Application number: 2025/93355	
What is the application for?:	Erection of 75 residential dwellings with associated landscaping, open space, hi
Address of the site or building:	Land off, Woodward Court, Mirfield, WF14 0PY
Postcode:	LS15 8ZB

Type of comment: An objection	
Do you wish your comments to be published on the website anonymously?	Yes
<p>I strongly object to this application for various reasons: Firstly in the highways report submitted it states that traffic in the evening peak is lower than during the previous application, this is most likely due to the fact that in this application the traffic count doesn't include the traffic that is going up and down Wellhouse Lane when Crossley fields school pick up occurs so doesn't cover all the traffic between 230pm and 4pm.</p> <p>A further report states that the 202 bus run half hourly Monday to Saturday, again this is incorrect as early mornings the buses are hourly and in early evenings the buses are hourly and also at one stage every 2 hours so yet another error by Bellway consultants</p> <p>The ecological and environment report does a good job at trying to indicate there is little wildlife around the site. I can confirm that

A Key plan updated.
STREETSCENES - 2520-SS-01A
WOODWARD COURT, MIRFIELD
BELLWAY HOMES
SCALE:1:200@A1 - NOVEMBER 2025

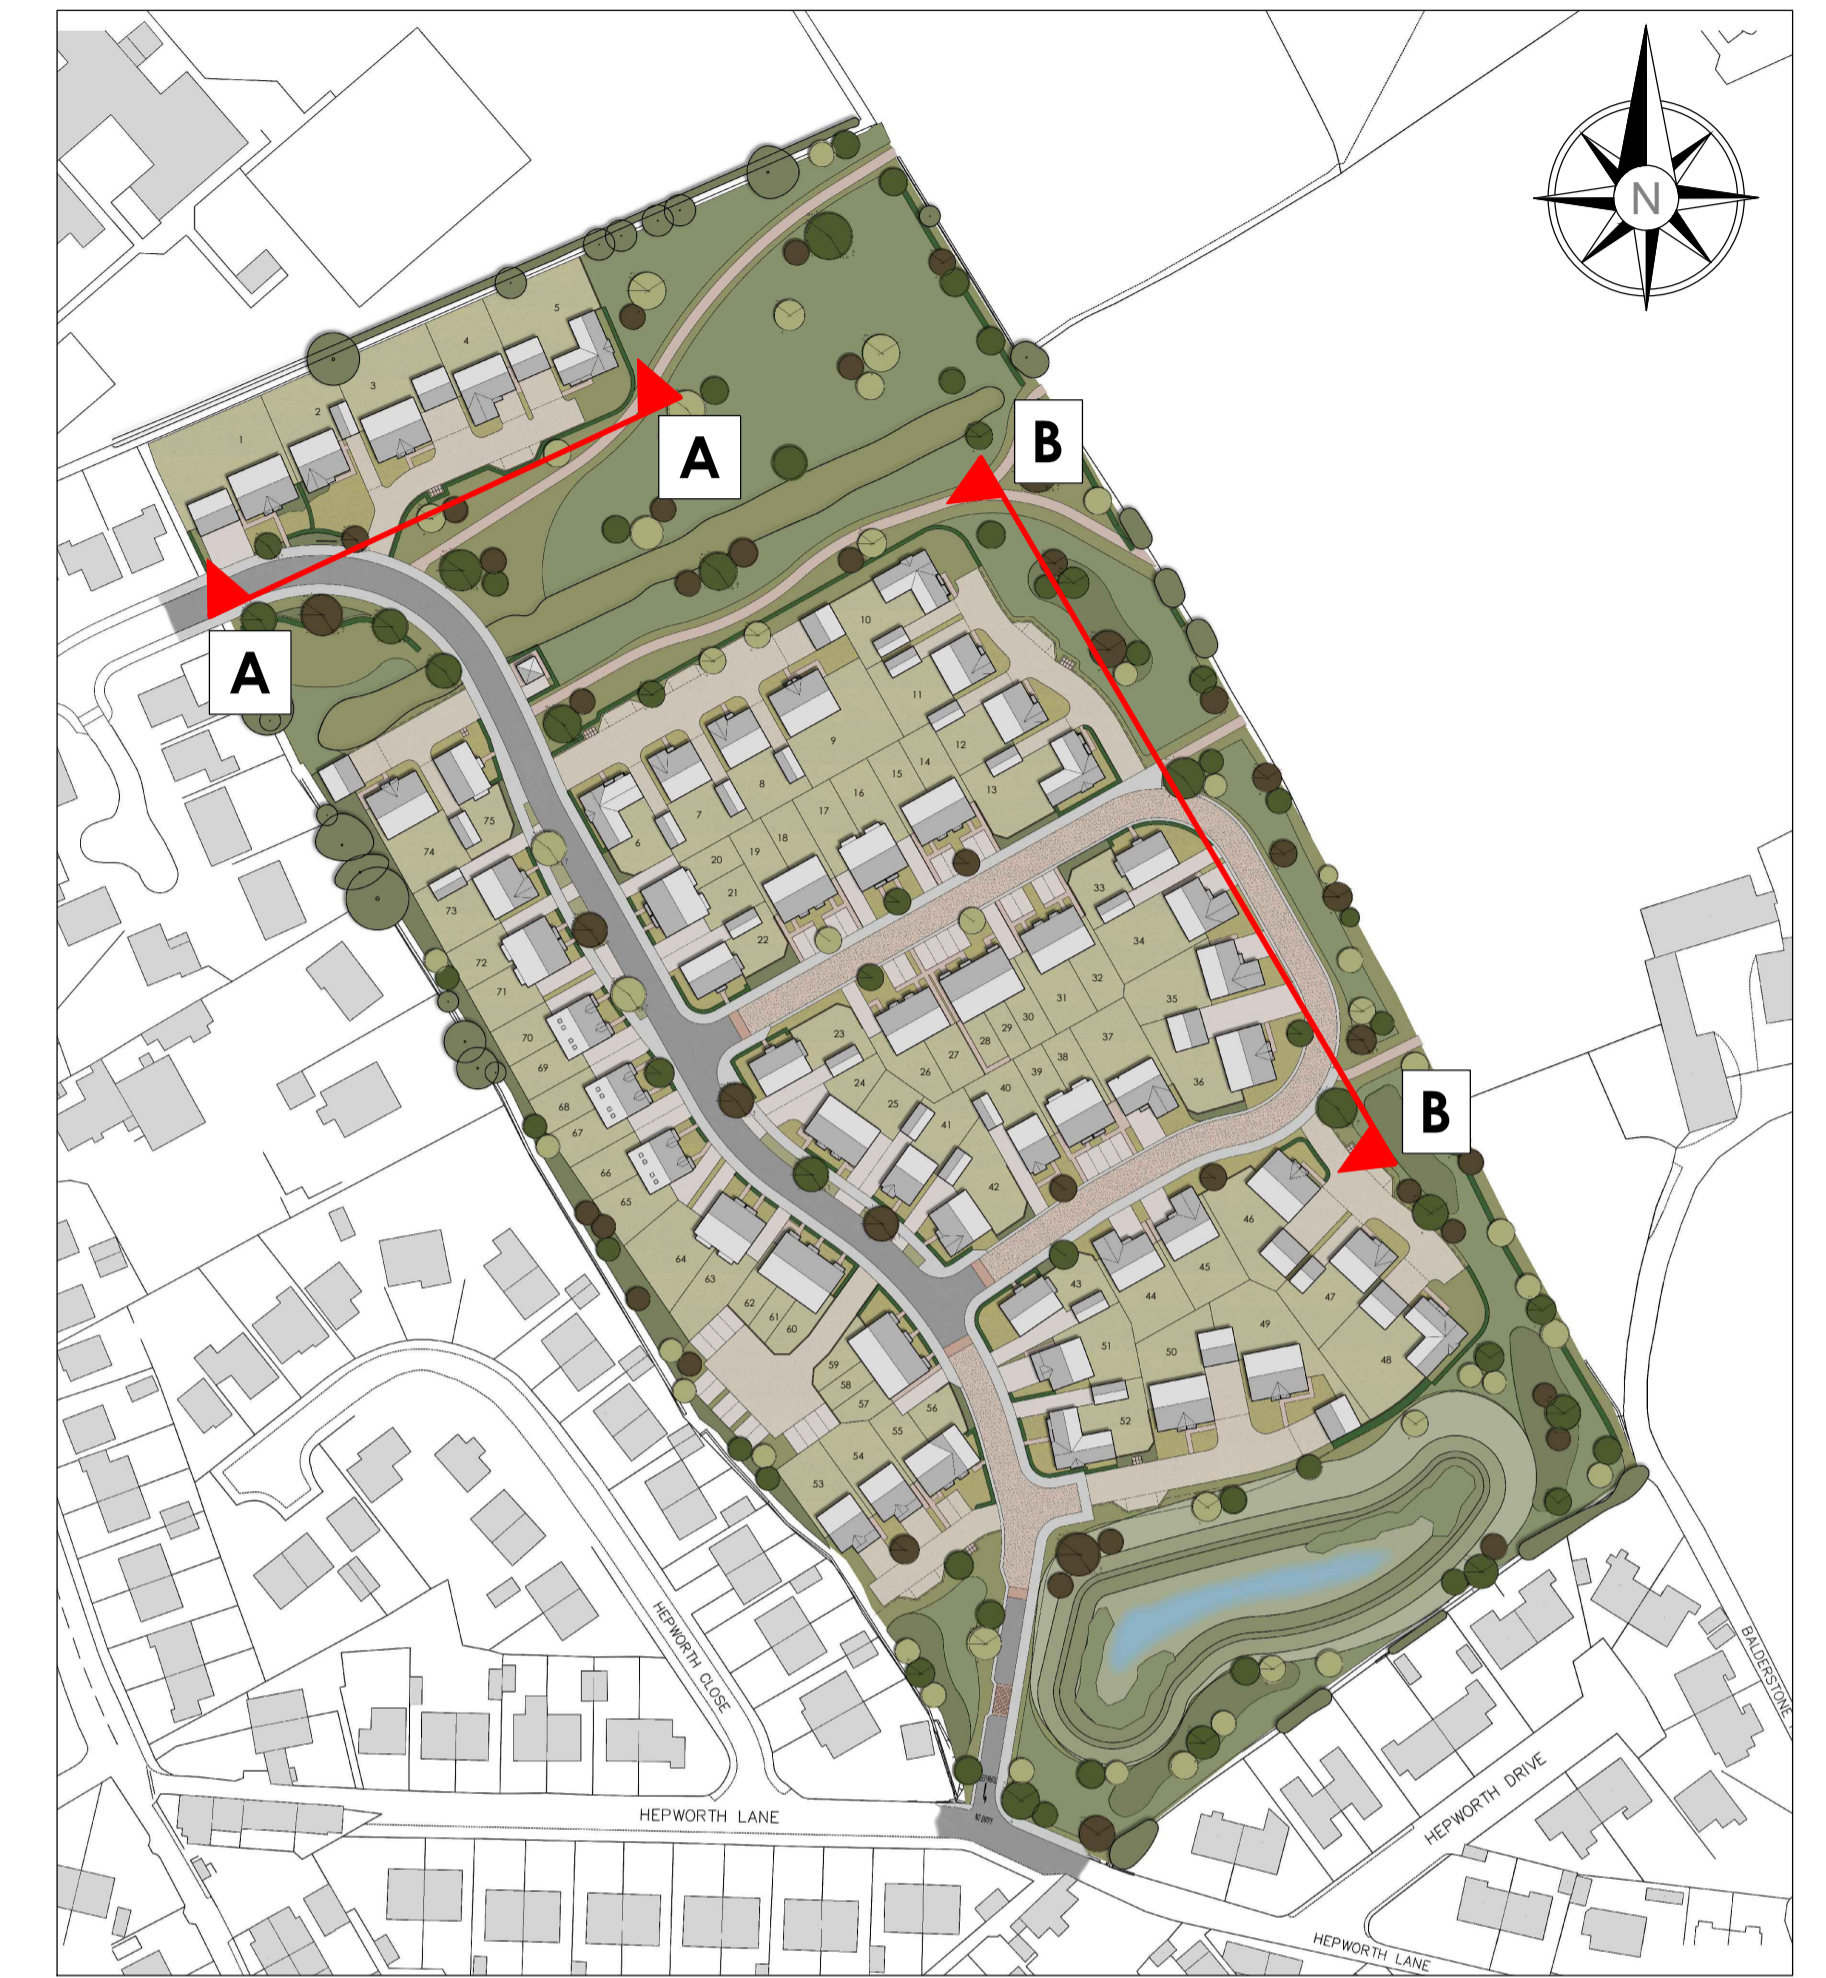
The two and a half storey proposed houses on the west of the site would be out keeping and would overlook and cause a loss of privacy for residents on Hepworth Close.

Image 3.4 Proposed Hepworth Lane Site Egress

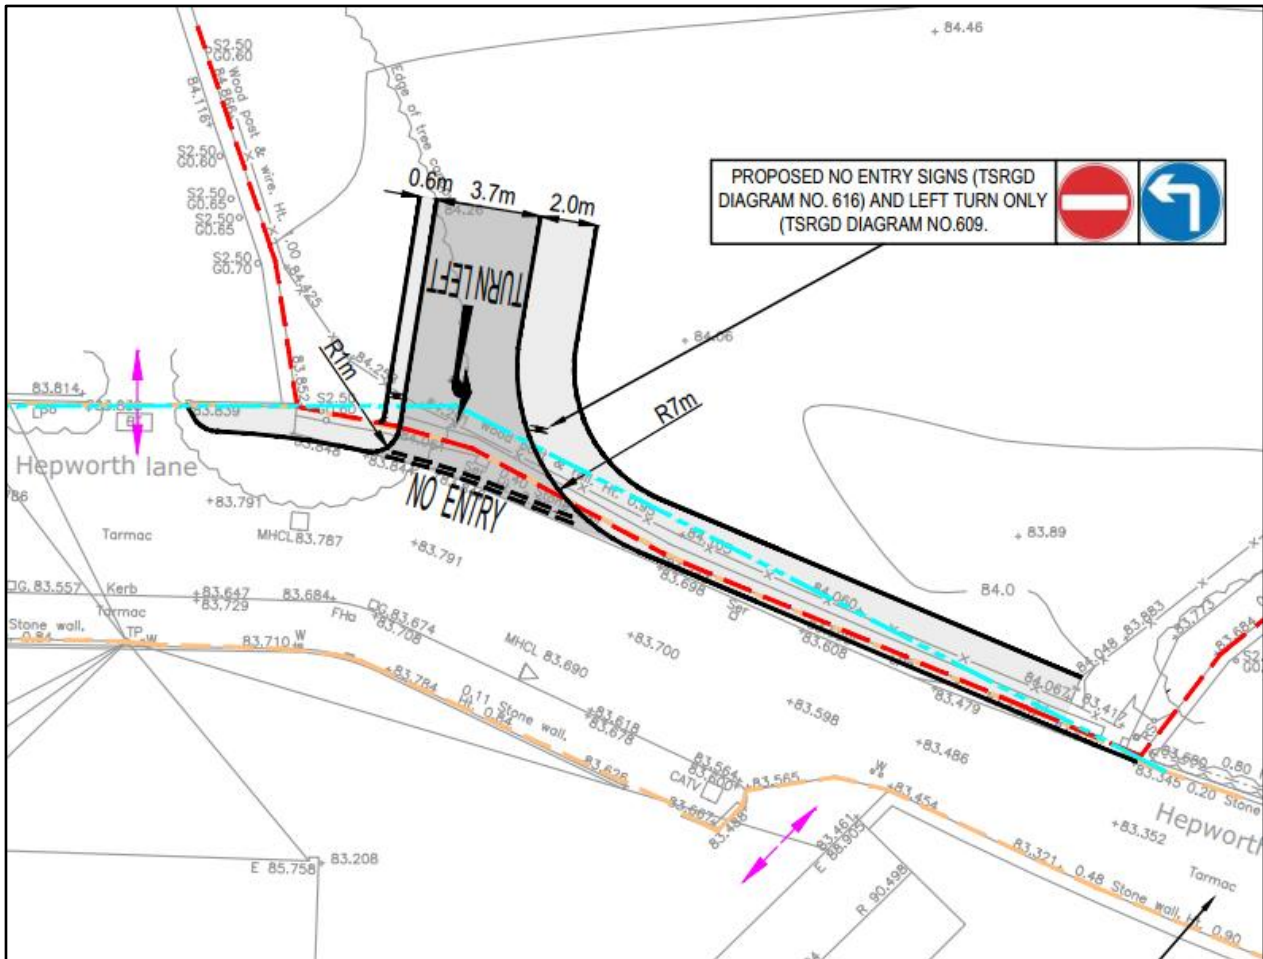
The proposed egress exit onto Hepworth Lane is ludicrous as the exit would be at one of the narrowest parts of Hepworth Lane and again sightlines would be poor. There would be little if no policing from the actual police or Kirklees to stop anyone doing an illegal right turn from the site or for anyone to enter the proposed site on an edit only road.
